FINAL SUMMARY
ELMESTHORPE PARISH COUNCIL
8th March 2024

- 4.3. In addition to this, when referring to appendix 4 Cycle Routes Options Tables **(6.2.8.1D Hinckley NRFI ES Appendix 8.1 Transport Assessment (Part 15 of 20) Sustainable Transport Strategy and Plan (Appendices) Rev 7)**

Enhancement 1: Improved junction safety by introducing a Toucan Crossing.

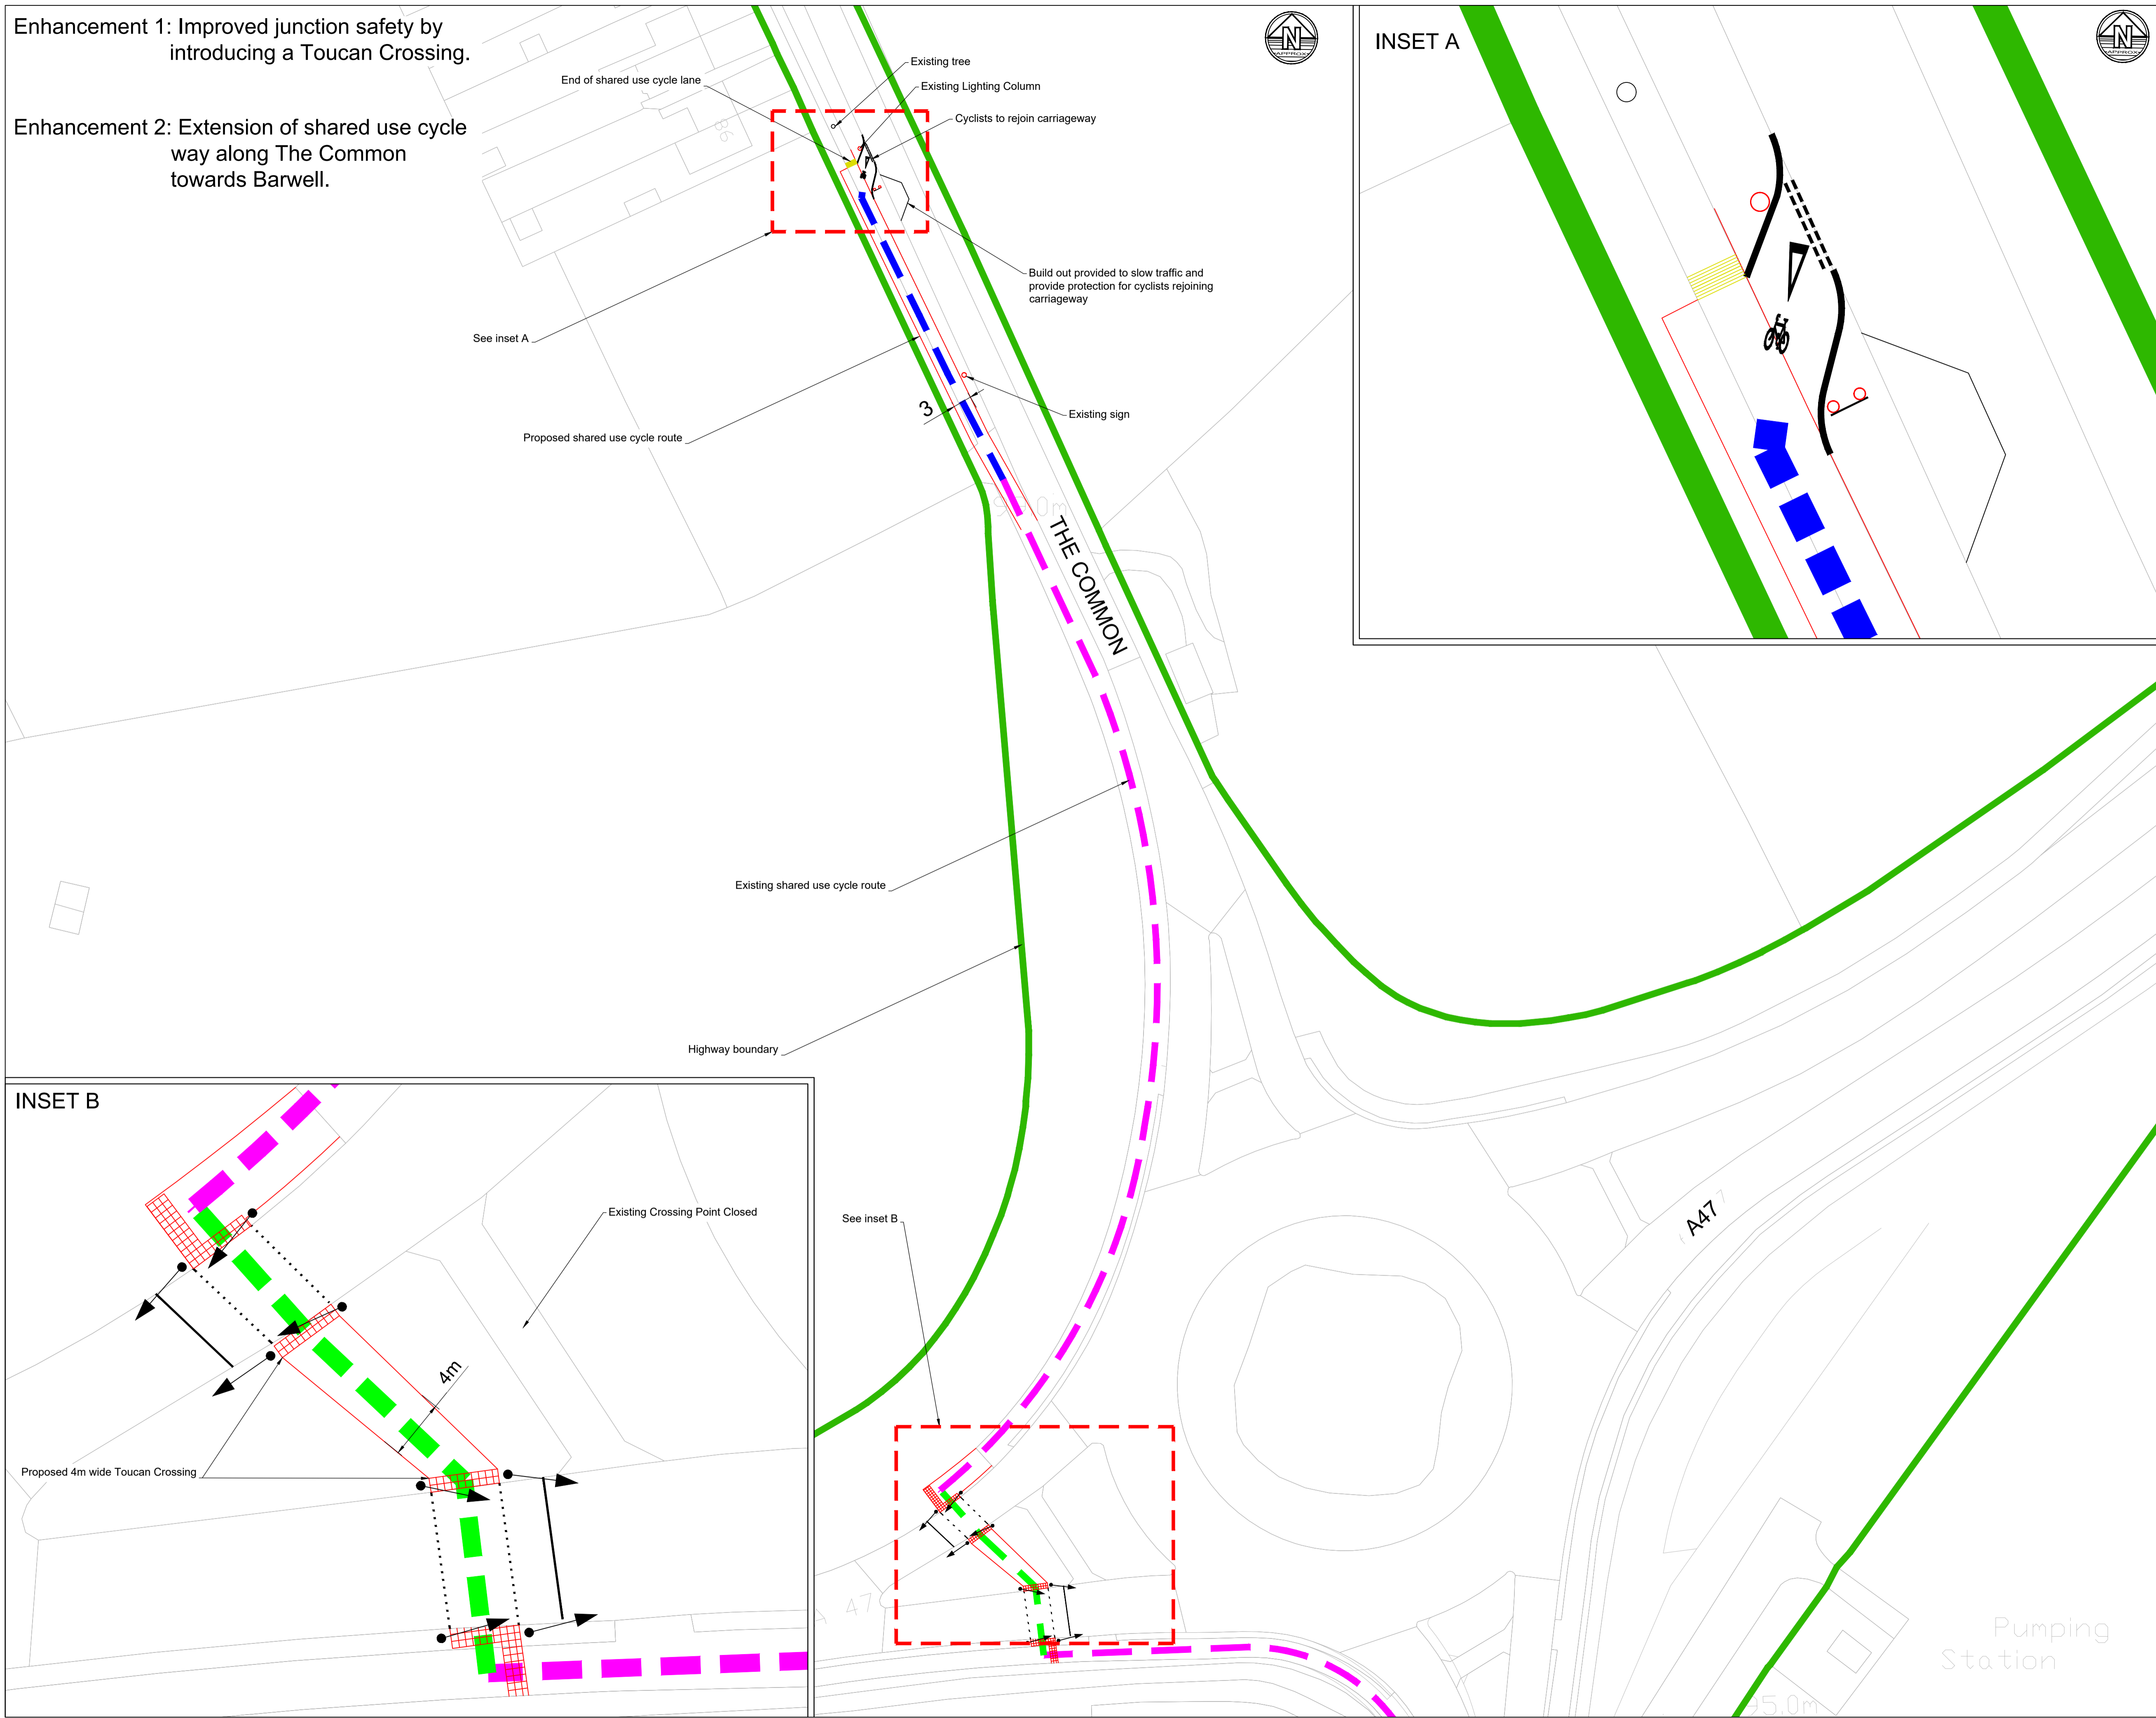
- 4.4. Enhancement Number 1: 'Toucan crossing over A47 [to enable] Safer access between Barwell and B4668.' The effect of introducing traffic signals could be significant when factoring in the large increase in additional traffic.

Enhancement 2: Extension of shared use cycle way along The Common towards Barwell.

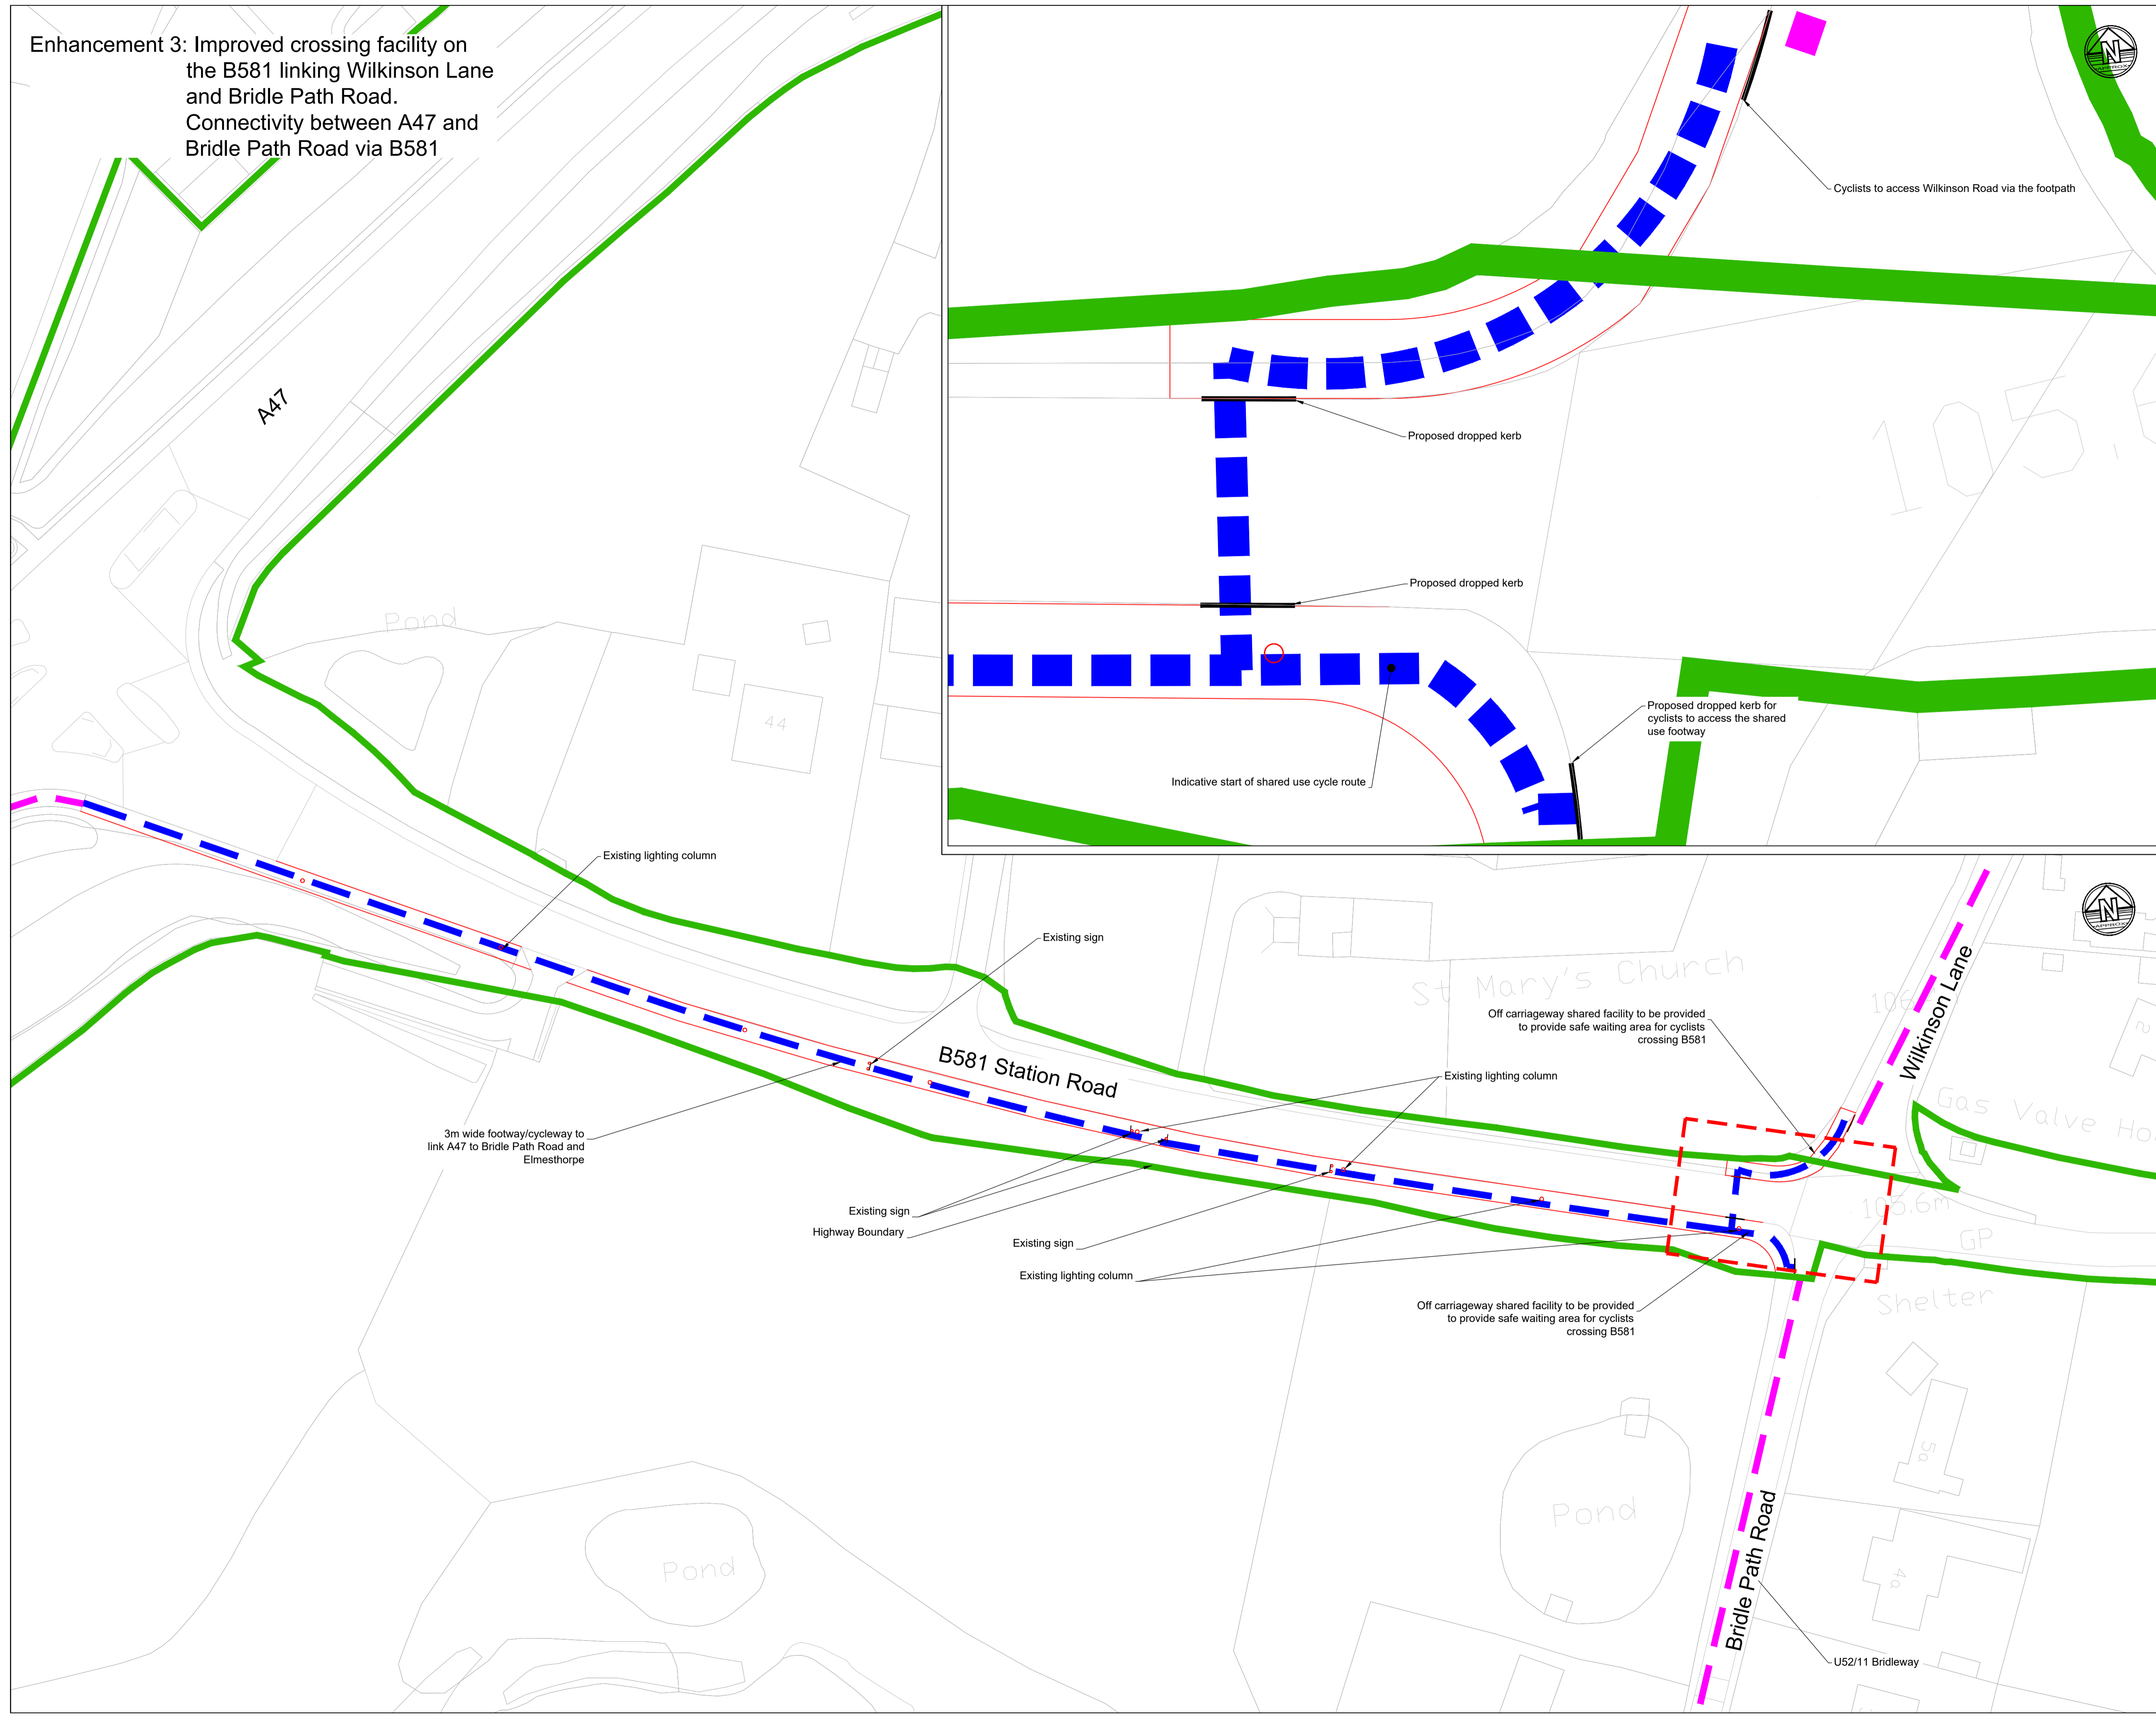
- 4.5. Enhancement Number 2: ...'Introduction of gateway feature to provide protection to cyclists rejoining carriageway.' As previously referenced, traffic on and around this roundabout stands to increase substantially with the introduction of the A47 Link Road, as a crucial part of the HNRFI route. Elements that could create potential delays and traffic queues on this roundabout need thorough assessment and modelling.
